TRAILS AT ASPEN RIDGE - STOCKPILE

GRADING & EROSION CONTROL PLANS

MAY 2023

EPC STORMWATER REVIEW COMMENTS
IN ORANGE BOXES WITH BLACK TEXT

<b>TRAILS AT ASPEN RIDGE - STOCKPILE</b>			
CONSTRUCTION DRAWINGS GRADING AND EROSION CONTROL PLANS			
<b>GRADING AND EROSION CONTROL PLAN</b>			
DESIGNED BY:	NMS	SCALE	DATE ISSUED: MAY 2023
DRAWN BY:	TRS	HORIZ N/A	DRAWING No. GEC01
CHECKED BY:	NMS	VERT. N/A	SHEET 3 OF 8

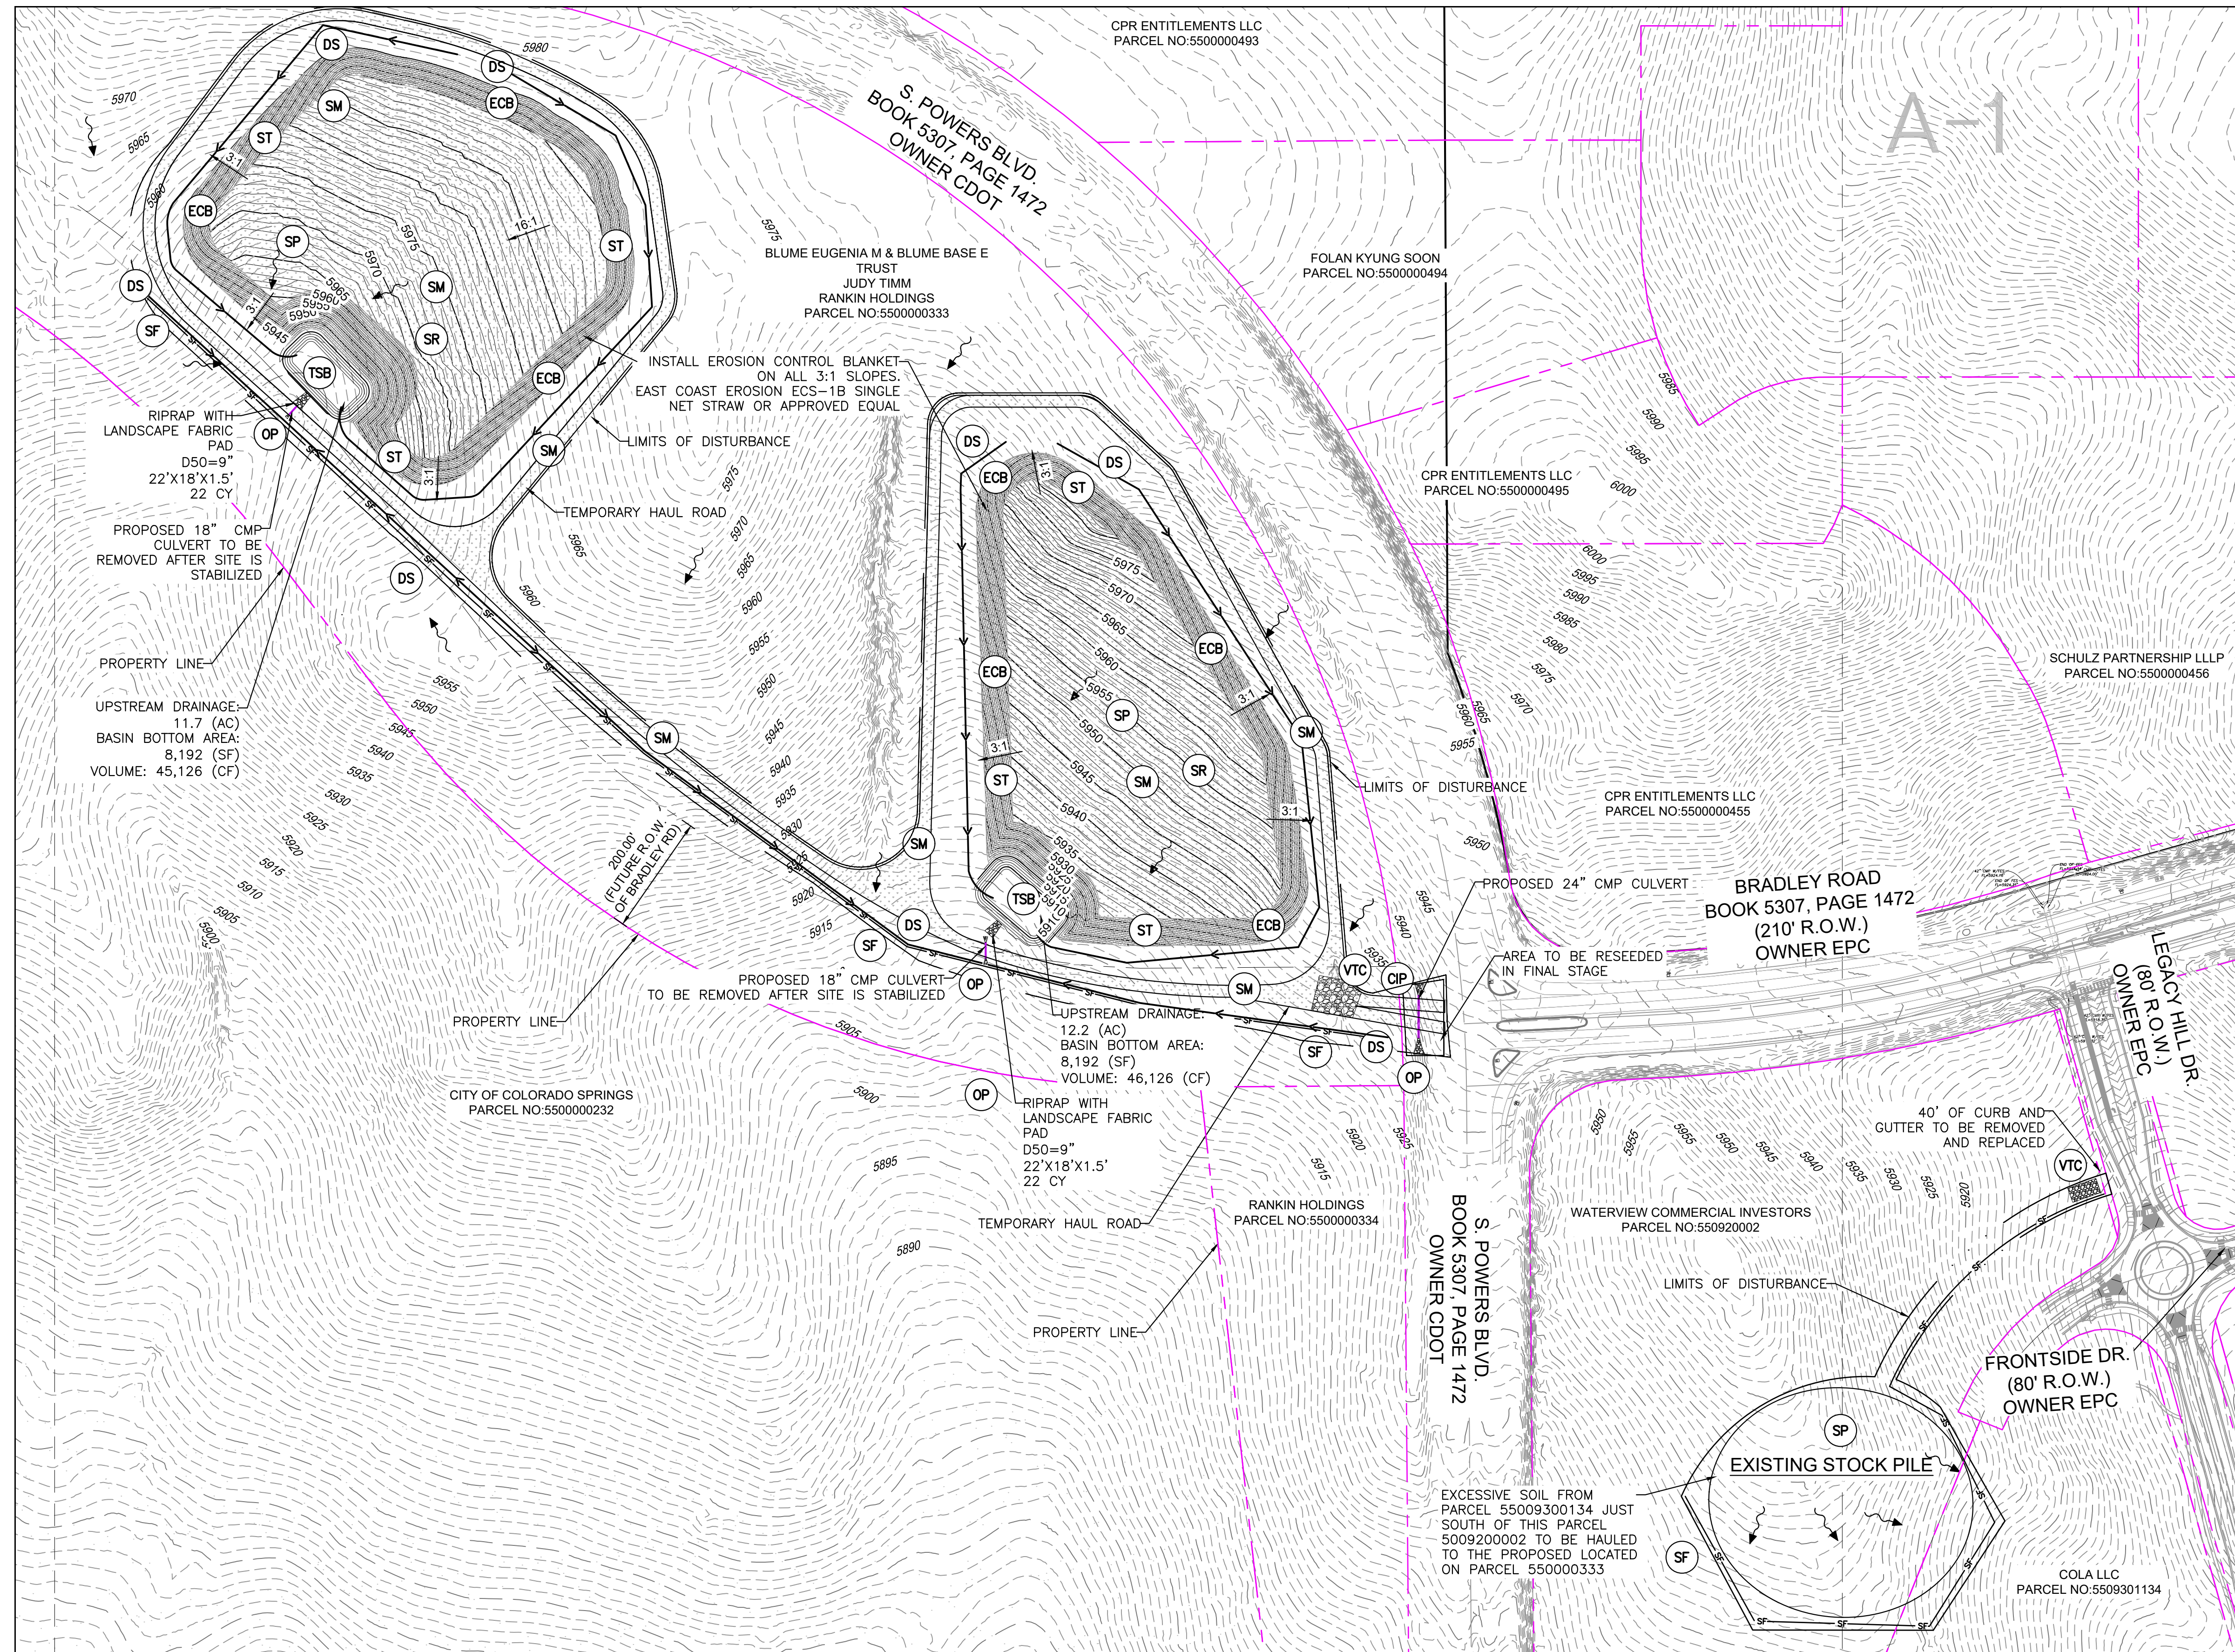
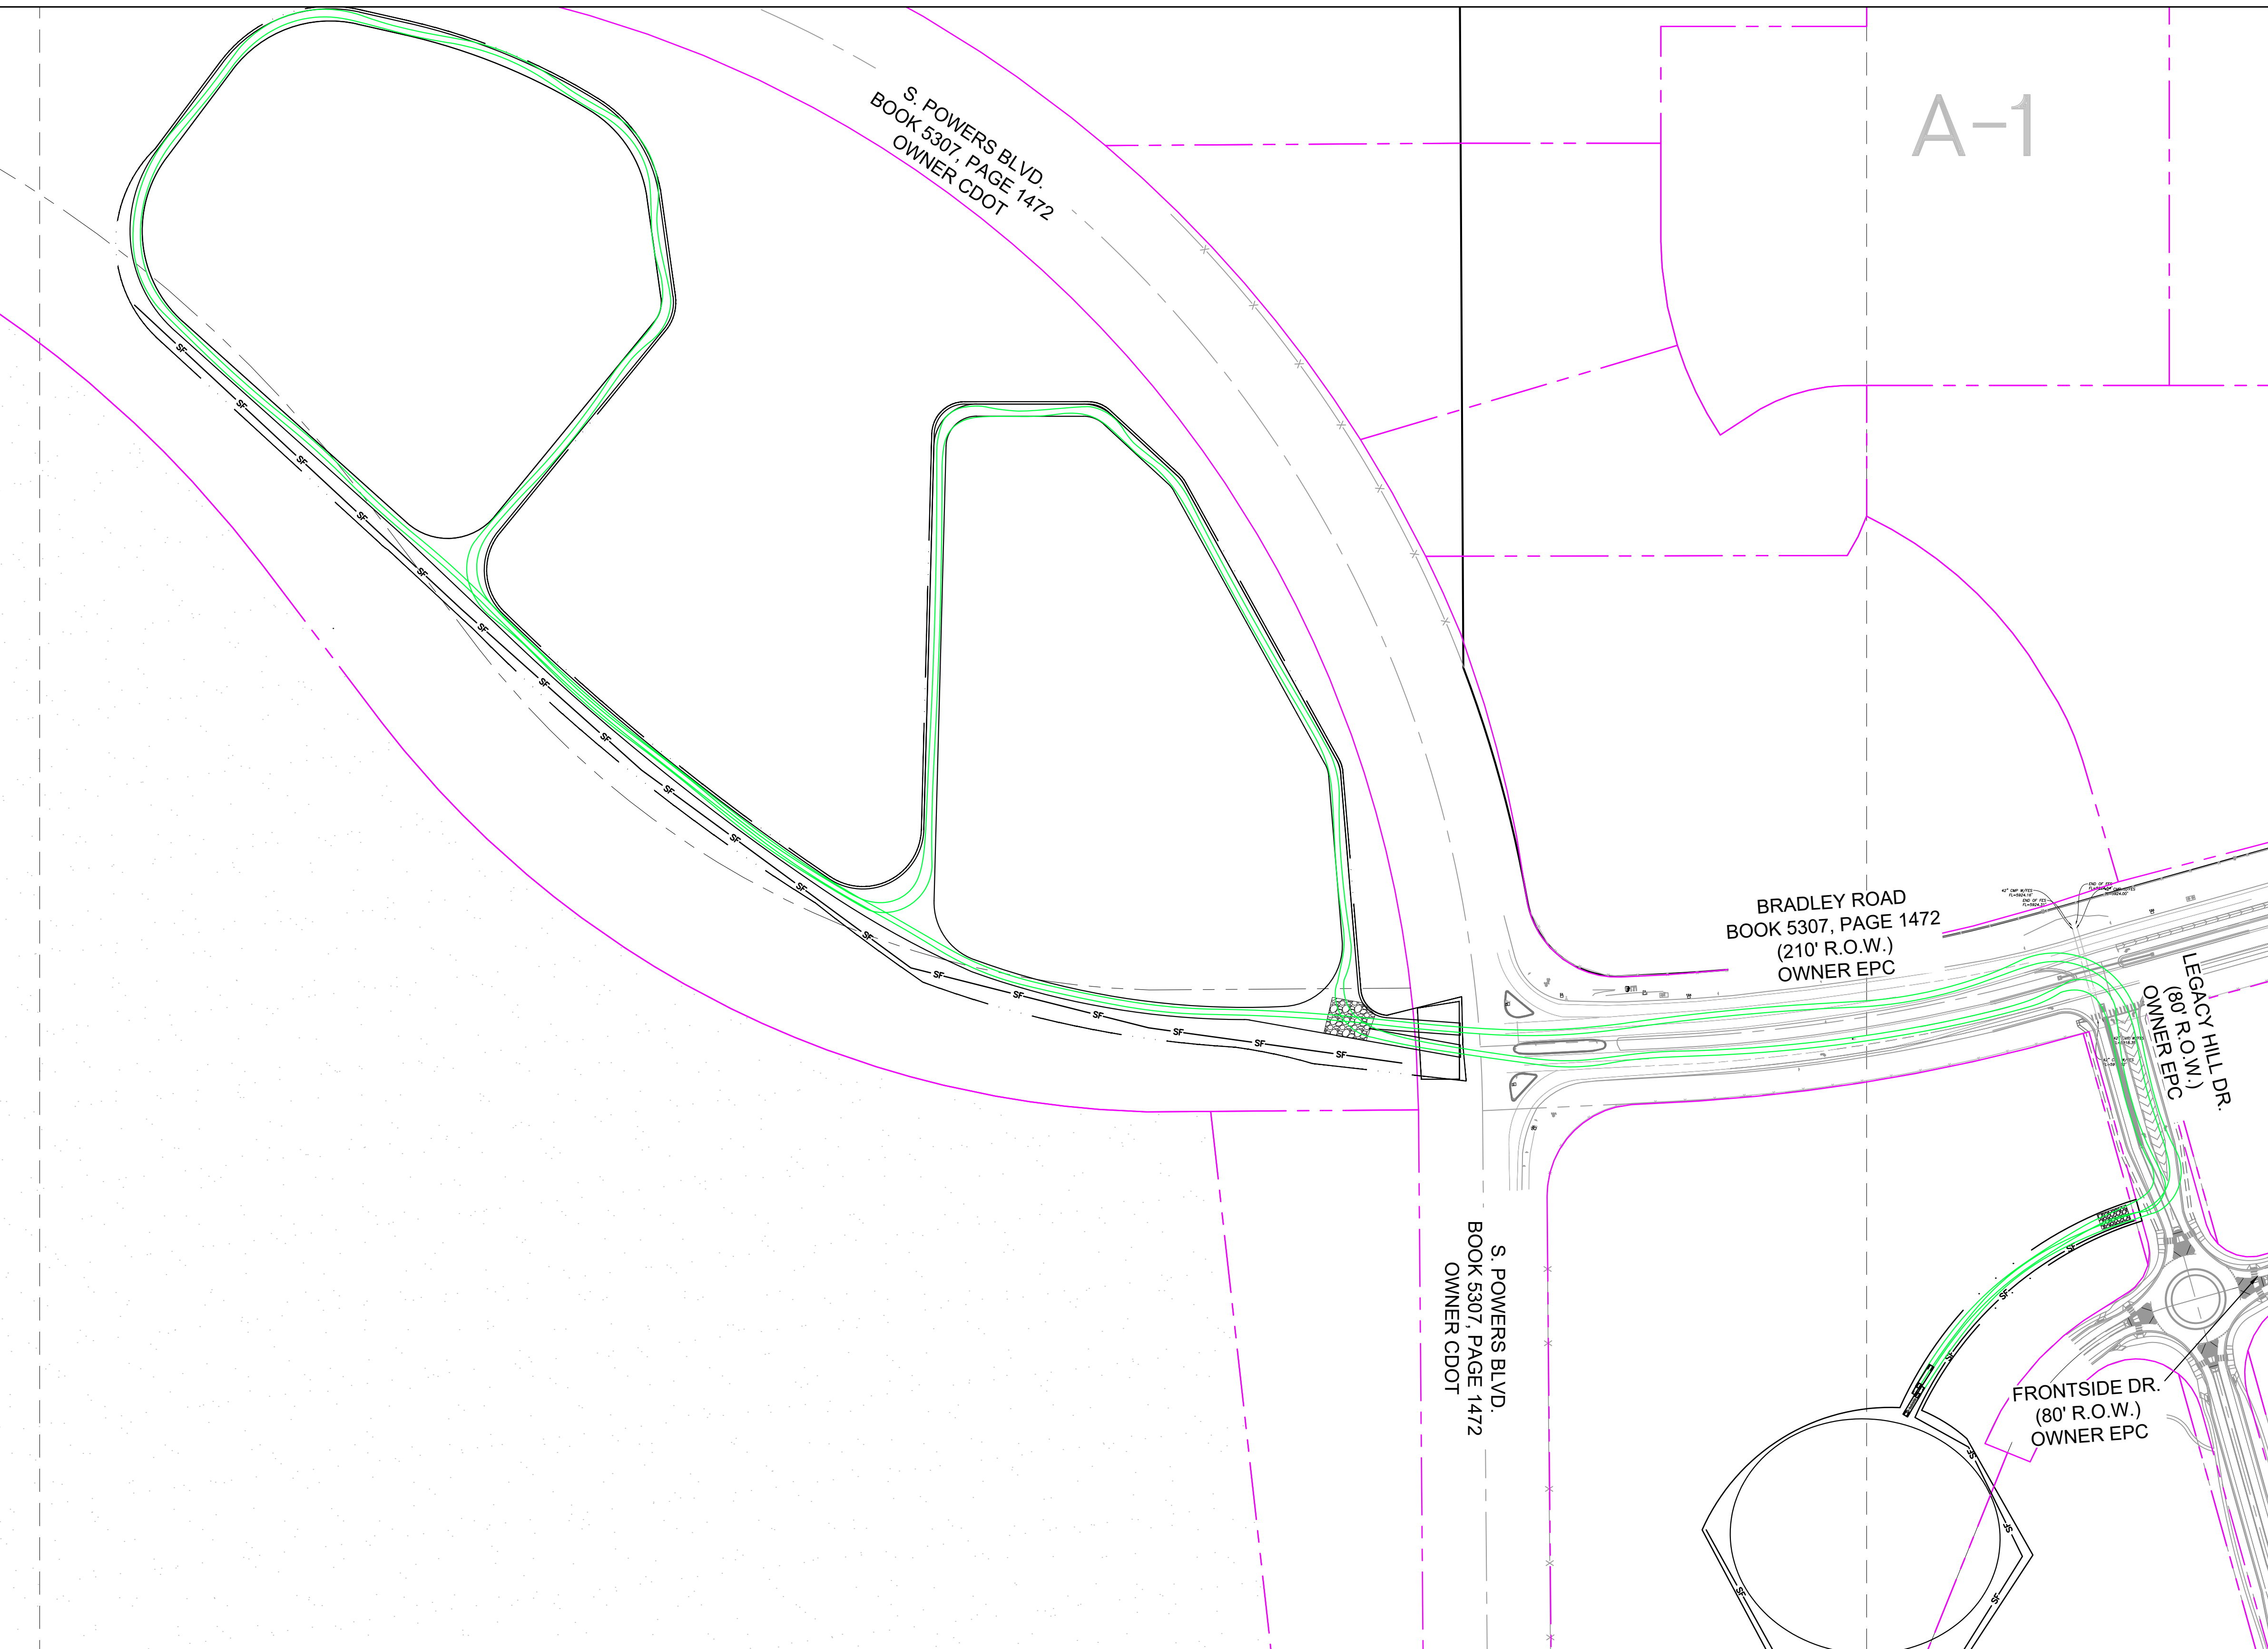
Note: Will need agreement with Waterview Commercial Investors for use of their site for haul/truck route. Also, an official "haul route" may be needed for use of Bradley Road. Information is being forwarded to EPC Capital Projects and will let you know once we have received any additional information regarding this requirement.

Per GEC Checklist Item "X" - TSBs are required for disturbed drainage areas >1ac. Both stockpiles (Site 1 and Site 2) are >1ac. It is not acceptable to have runoff from several acres of untreated disturbed areas discharge to the park land south of this parcel.

Why SM not shown on stockpiles? These areas will need to be temp and permanently stabilized during and after construction, respectively.

Label grade of these steep slopes. The relevant Soils Report referenced on the previous sheet (from SF192) does not discuss suitability of soils to be stockpiled and with such steep slopes. Add a note to this sheet addressing any height, slope, or compaction/moisture req's for the stockpile.

Check dams to be installed a minimum of every 1.5' of vertical fall. Note spacing and/or include a table for multiple slopes, based on your selected detail, per the example table shown below.

show surface roughening on both stockpiles if SM isn't practical. *See comment in lower left corner.

How will flow be conveyed past the haul road? Culvert? Texas crossing?

Per GEC Checklist Item "S" - show stormwater flow direction arrows.

There is >1ac of disturbed areas tributary to these 2 points. Therefore TSBs are necessary. *See comment in lower left corner.

Provide fabric or bedding material beneath riprap pads, if deemed necessary based on soil conditions.

What is the intent with concentrated flow that is conveyed to this point? No culvert or OP provided. Did you mean to continue the DS to connect with the western CD like was done with the other stockpile?

Show linework for Powers like edge of pavement, if you have it.

Add a callout here with an arrow pointing out of the viewport that states something like "excessive soil from Parcel 5509301134 just south of this Parcel 550920002 to be hauled to the proposed stockpile located in Parcel 5509301134."
